Sutherland Hospital**Landscape Statement by the Consultant**

Project: Sutherland Hospital

Landscape Architects: Arcadia Landscape Architecture Pty Ltd

Relevant Landscaping Documentation - Issue 2 13.3.2021

LANDSCAPE PLANTING AND SHADE CONSIDERATIONS

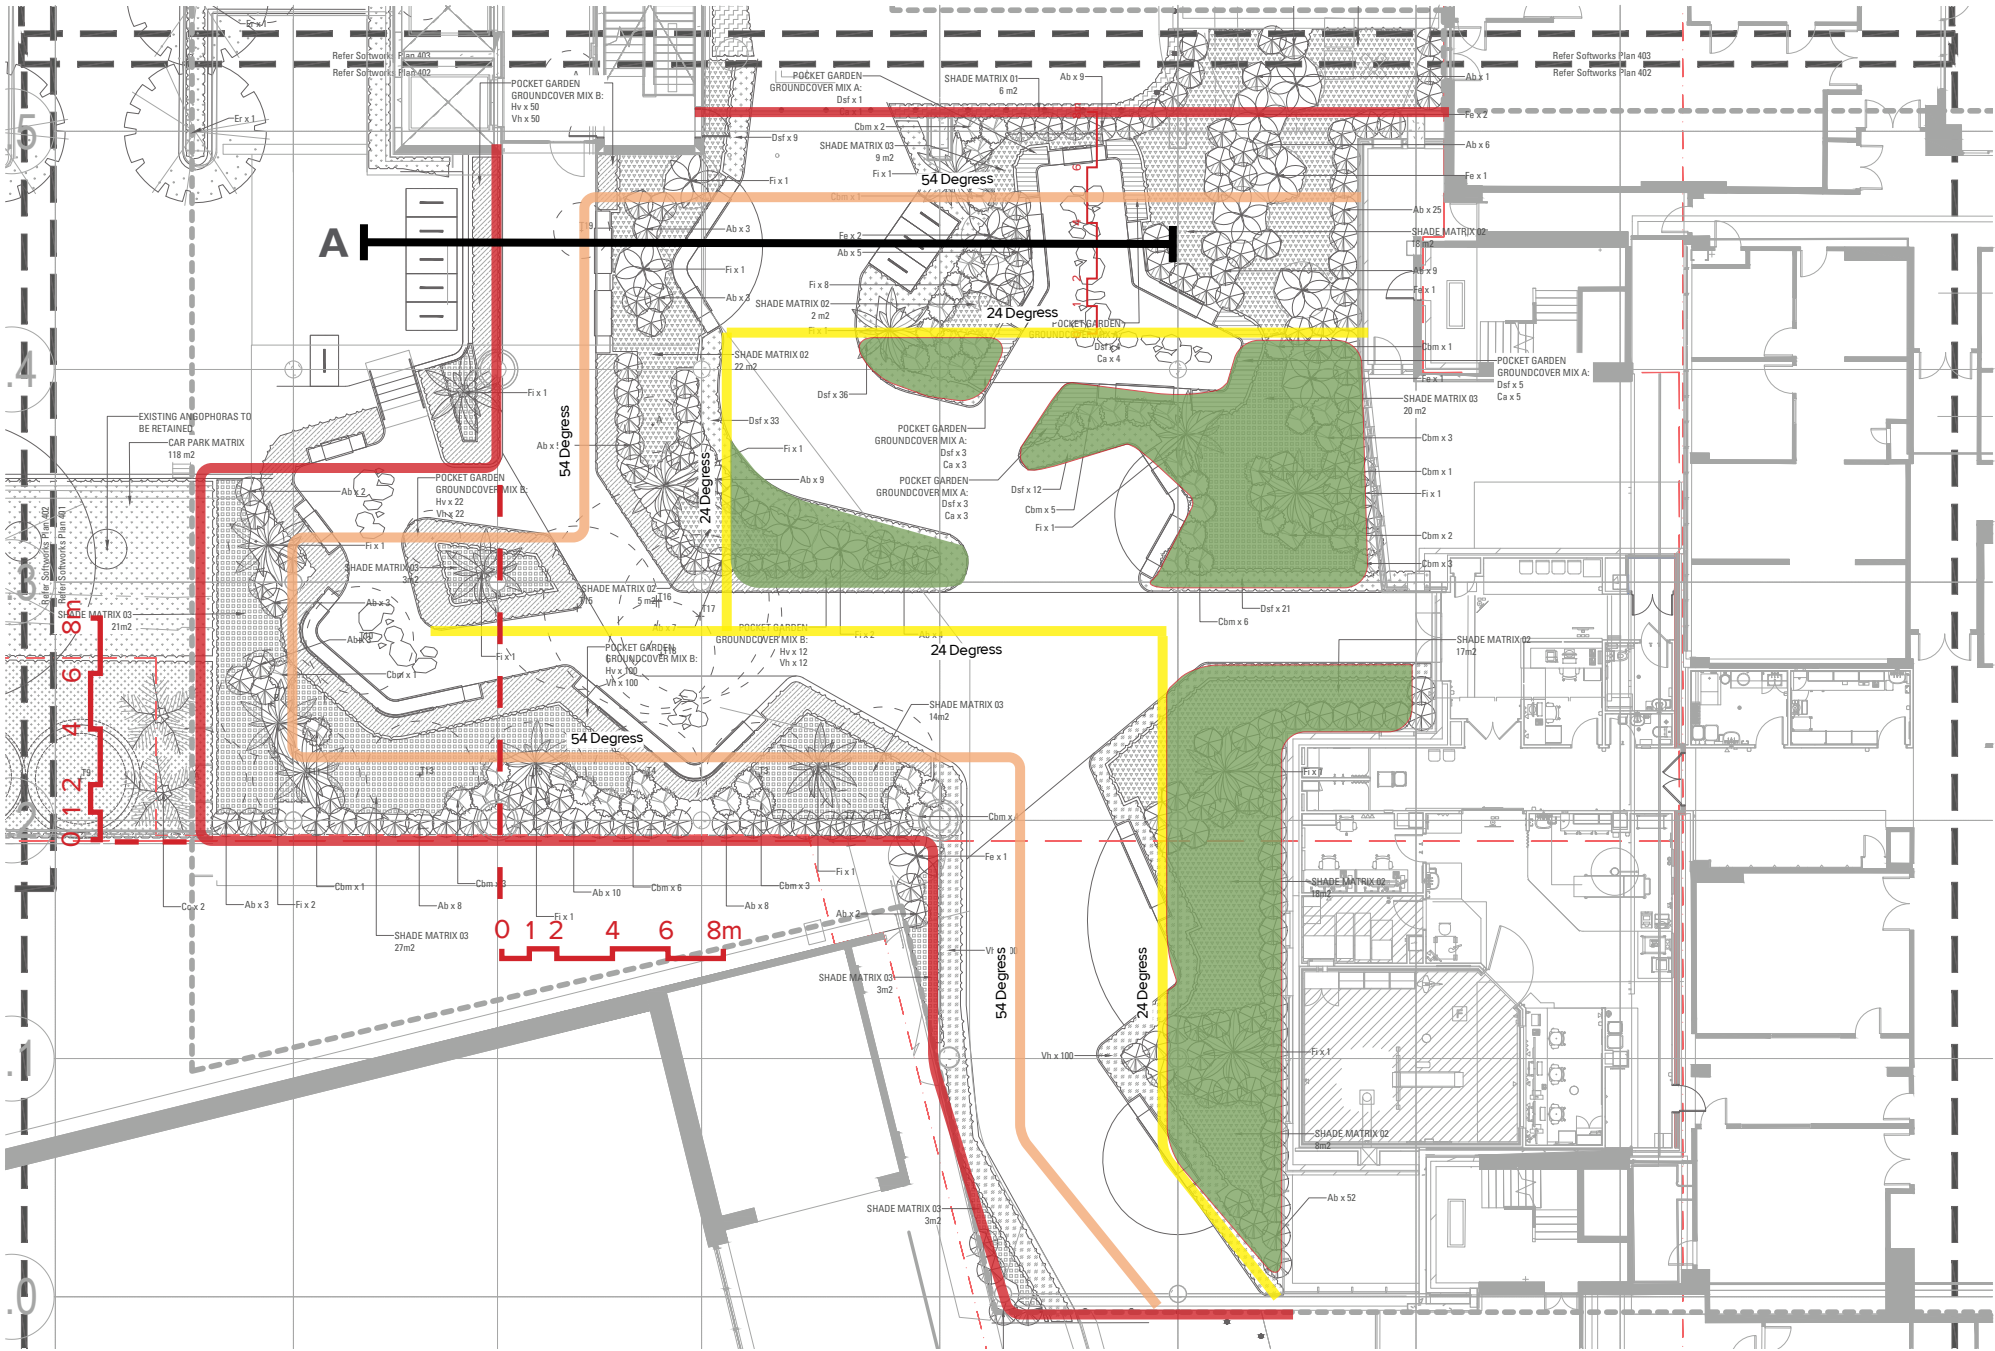
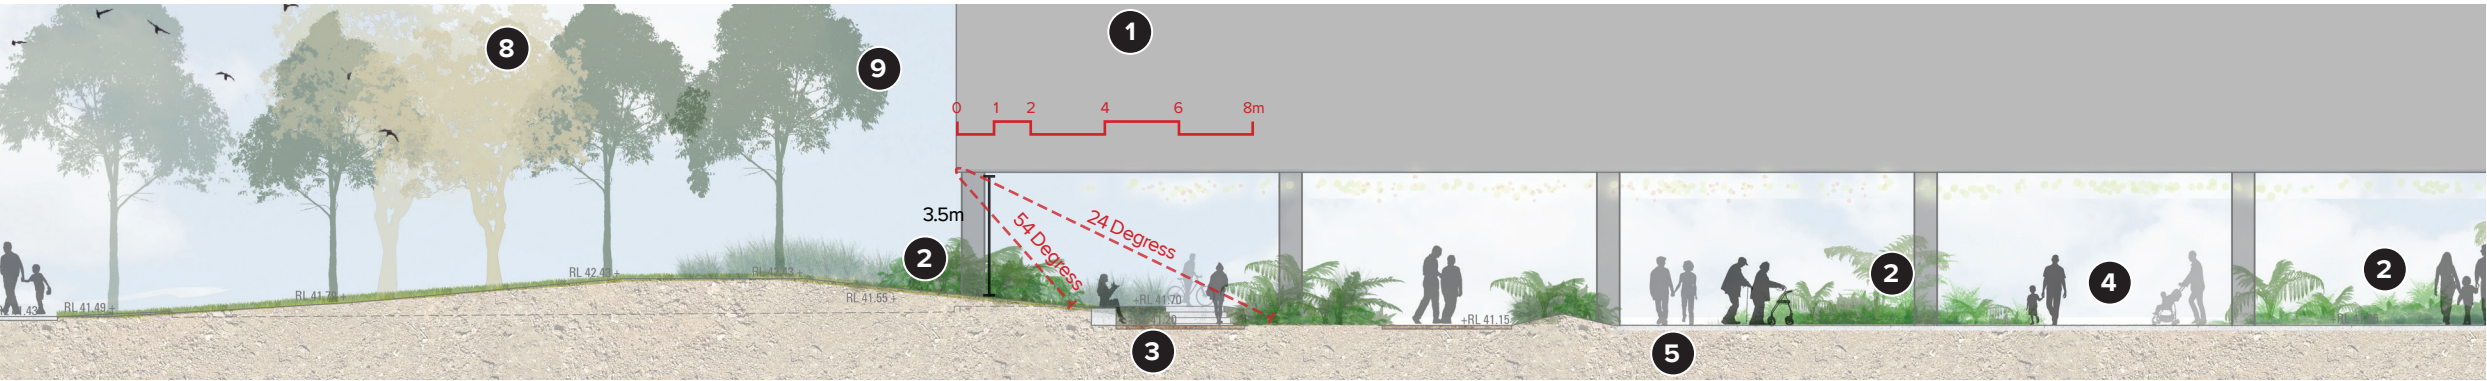
“10 trees including Syzigium, Eucalyptus and Corymbia species are to be removed. Council's tree replacement ratio of 8:1 is recommended to form a condition of consent as recommended in the addendum to this letter. Further, proposed tree species require substitution to better reflect species that are endemic to the Sutherland Shire. This is also detailed within a recommended condition of consent.”

With regards to the design, the trees selected are of the Sydney turpentine-ironbark forest, North Hinterland Wet Sclerophyll Forests and Coastal enriched sandstone dry forest which is found from Arcadia Background research. No professional ecological input has been provided.

We would be more than happy to change the planting species to better reflect the request from Sutherland Shire Council.

The physical landscape area provided after accommodating the existing car park and building footprint is limited. This limited physical scope only allows for a certain number of trees to be planted - 19 Trees. The landscape design looks to provide as many trees as possible.
